Your Ref: OWPC16355
Our Ref: EP/138/17/PL 29-09-2017
Please ask for:
Mrs A Gardner

Demolition of existing buildings & erection of 3 No. dwellings with associated parking,
alterations to existing access & relocation of staircase to flats.

Land Rear of Beechlands Cottages Beechlands Close East Preston

Proposed Site Plan, Block Plan
and Location Plan

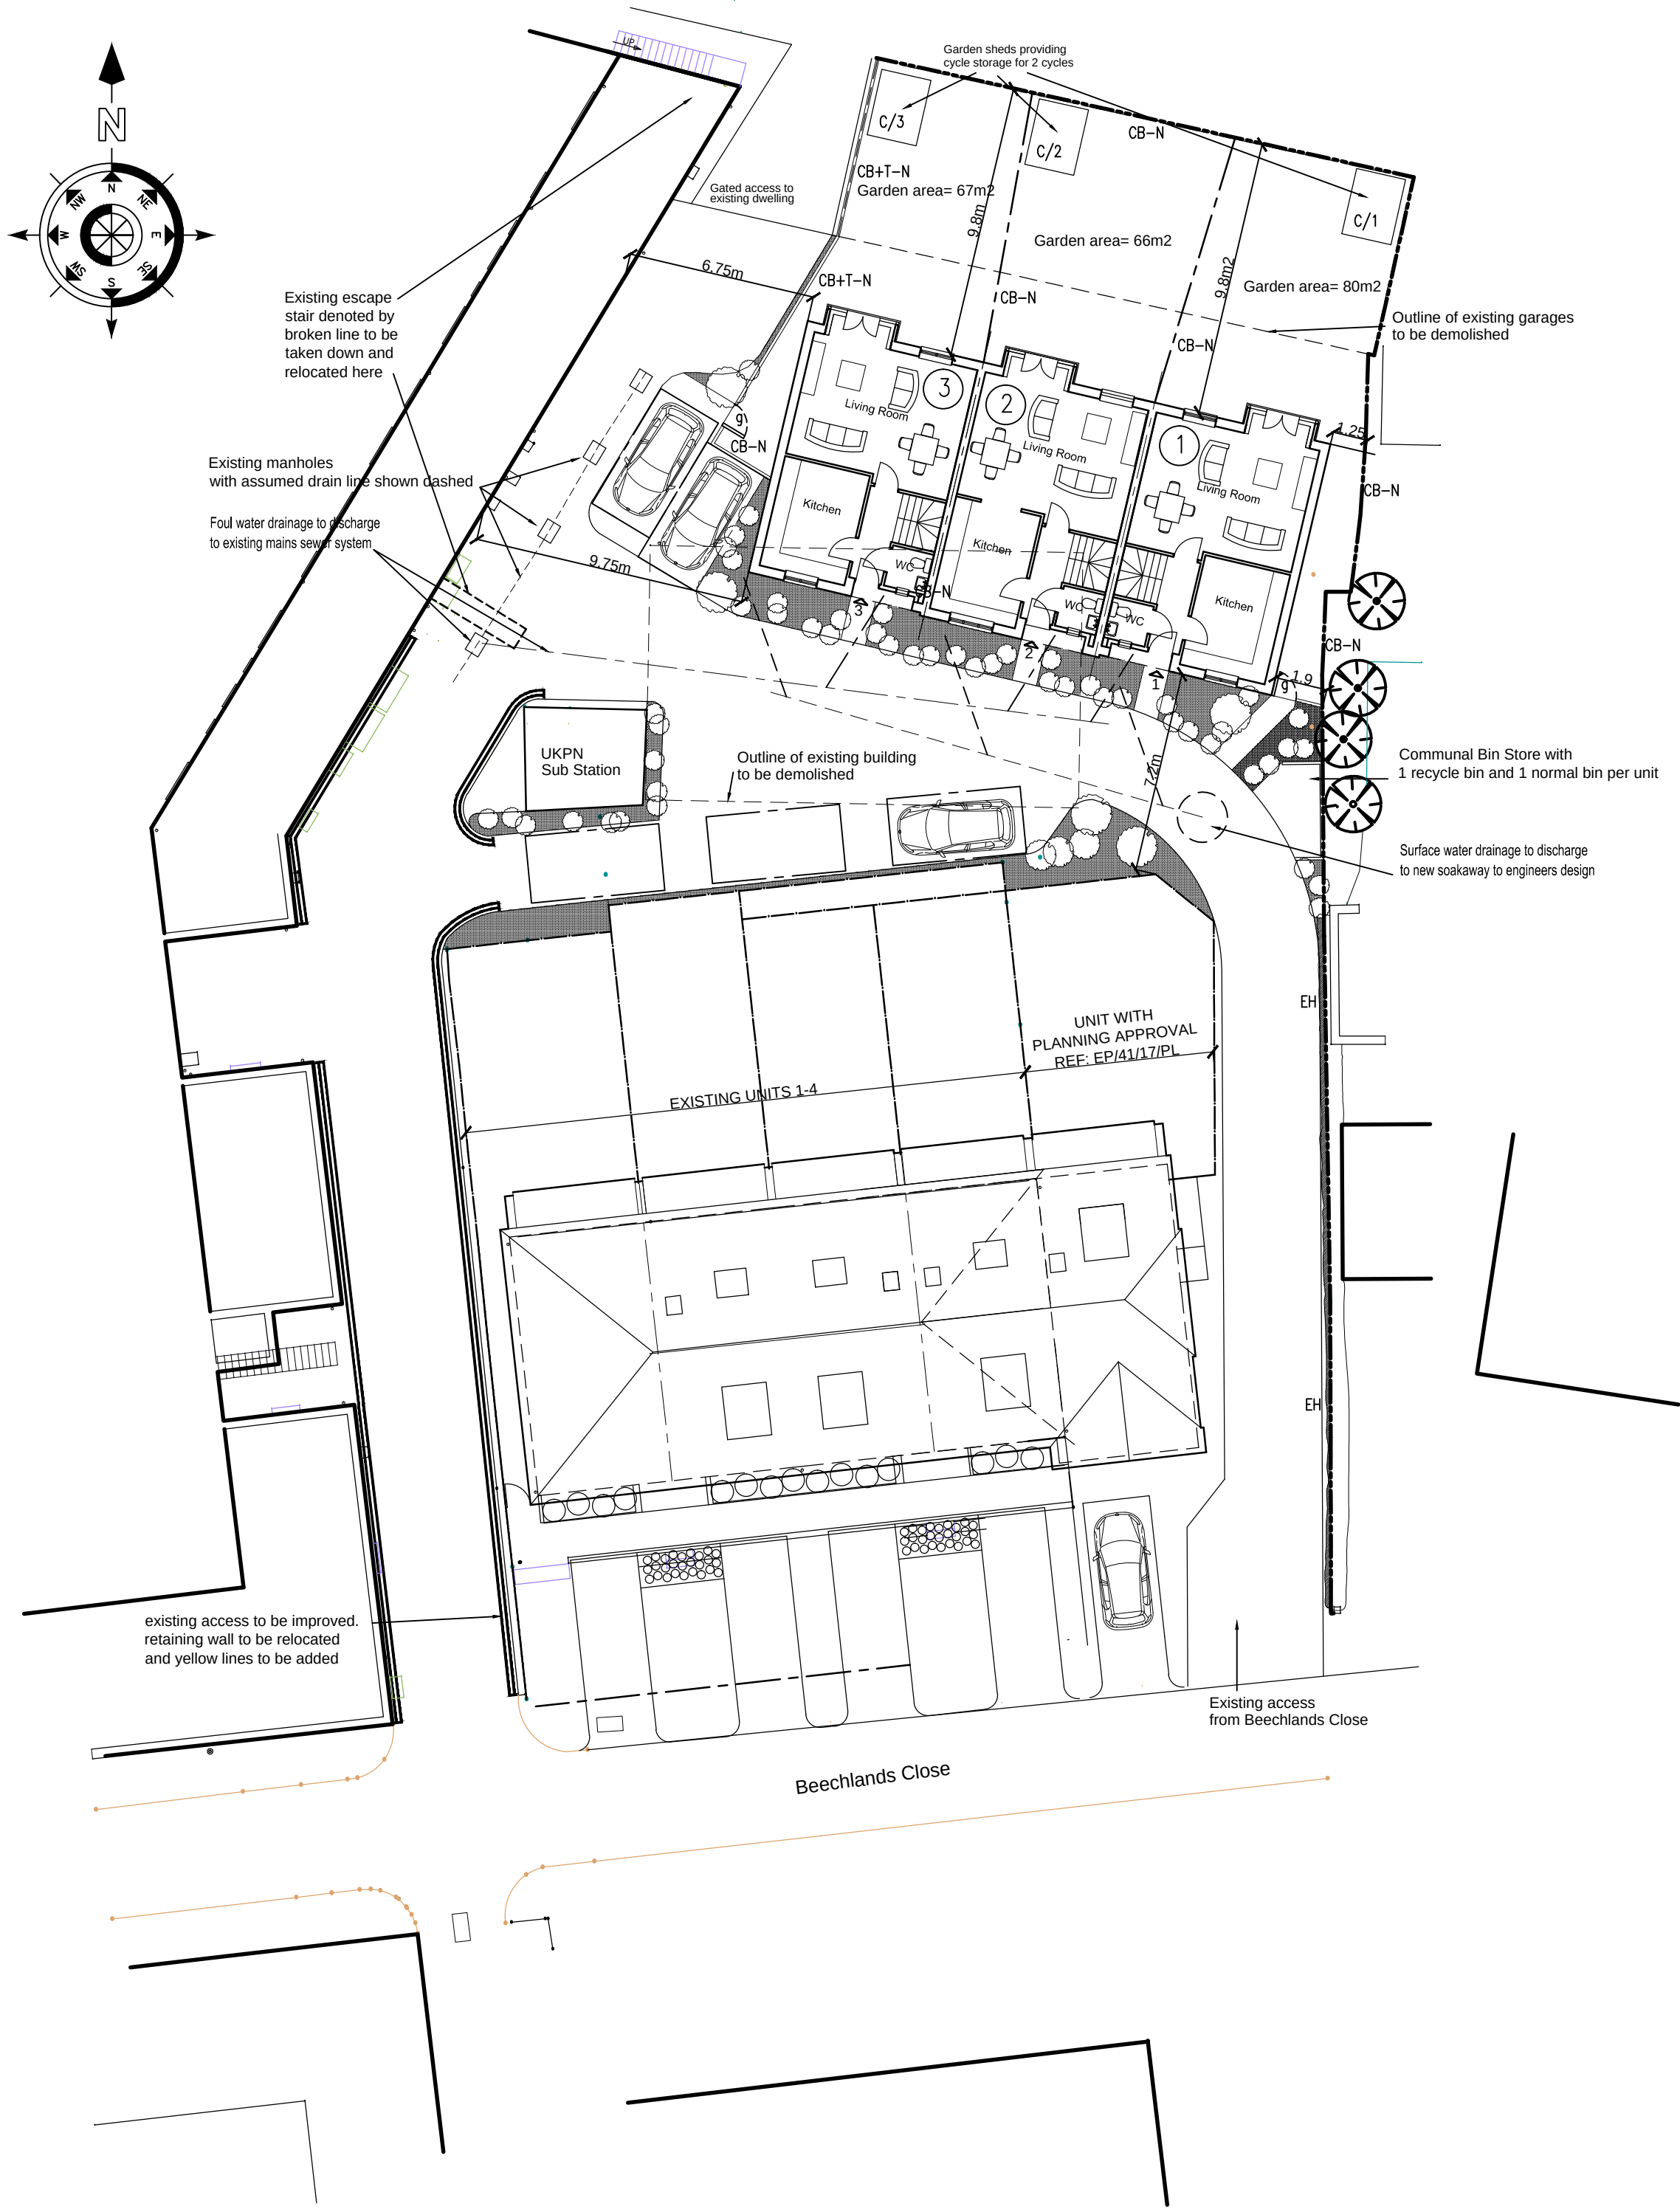
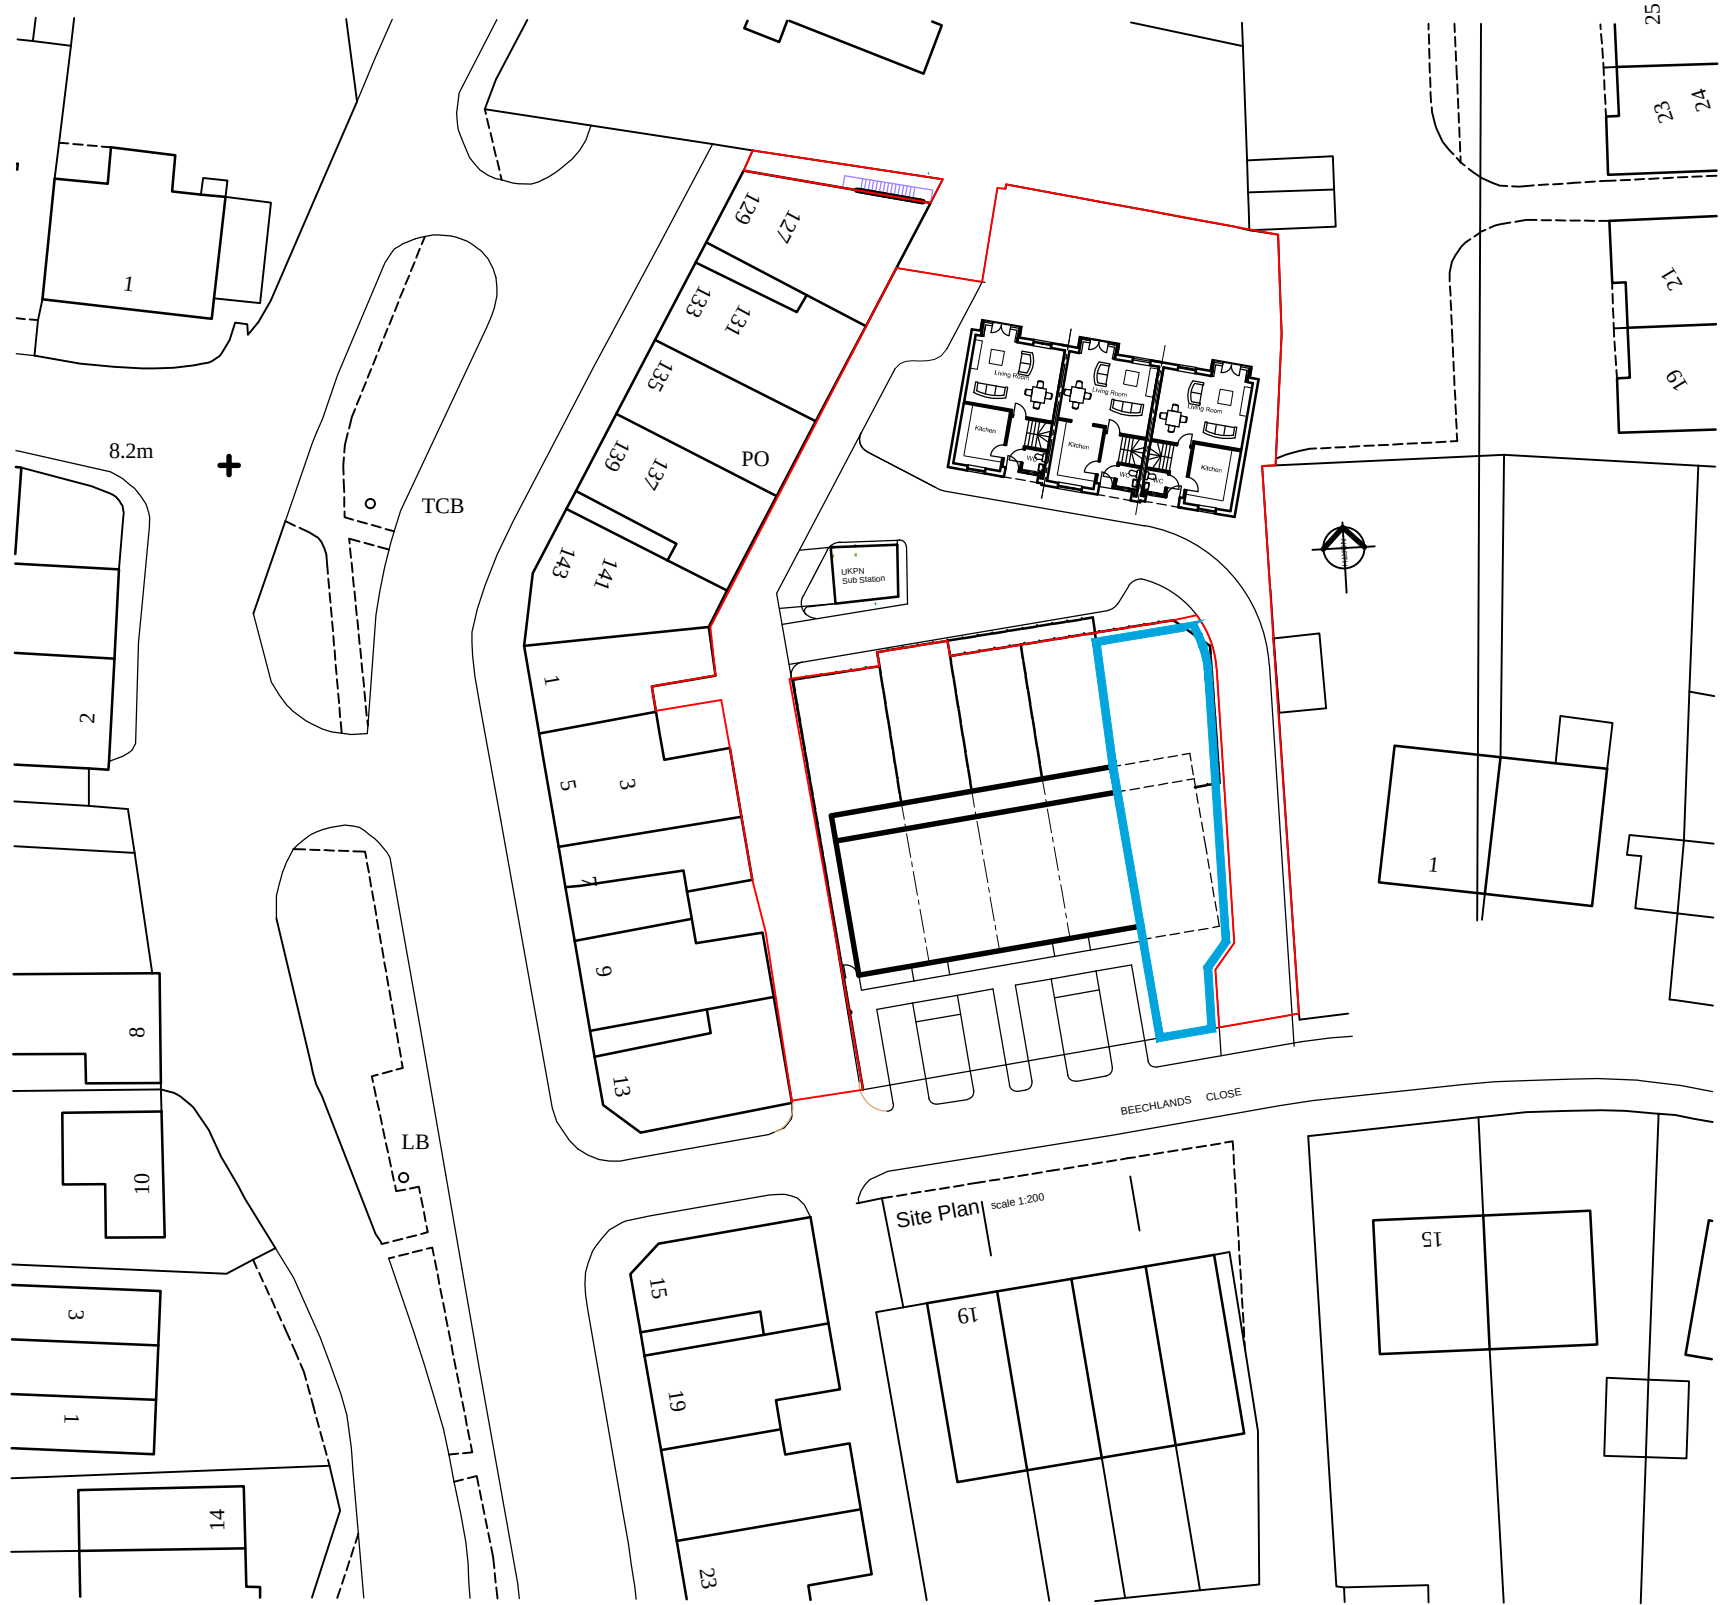
The current area behind the shops owned by Eurosite Ltd shows "existing access to be improved, retaining wall to be relocated and yellow lines added but no explanation as to why .

Is this the new or altered vehicle access proposed to or from the public highway ?.. or are there no new public roads to be provided within the site ?

If so, what provision will be made for pedestrians and the two different landlord's tenants using this route ?

Fire escape doors from several of the retail outlets open directly onto this area along with an additional metal fire escape for tenants over the Eurosite owned shops at this end of the parade and all require safe passage in an emergency.

The answers provided in item 6 pedestrian and vehicle access roads and rights of way are lacking in detail, unclear and contradictory. No mention is made of the rear fire escape doors to the various retail premises in the proposals

This development if approved will prohibit the current delivery of goods or retrieval of waste from the rear of the parade of shops by making it difficult for large vehicles to manoeuvre ,they will join the other delivery vehicles at the front of the parade ,or park in North Lane /Sea Road on the 700 bus route, causing further misery and inconvenience and hazards to other road users and pedestrians. One Stop alone require a delivery by their own articulated truck plus, P & H Foods, Robert Wiseman Milk , Hovis and Warburtons ..Daily ..7 days a week ..at the front..
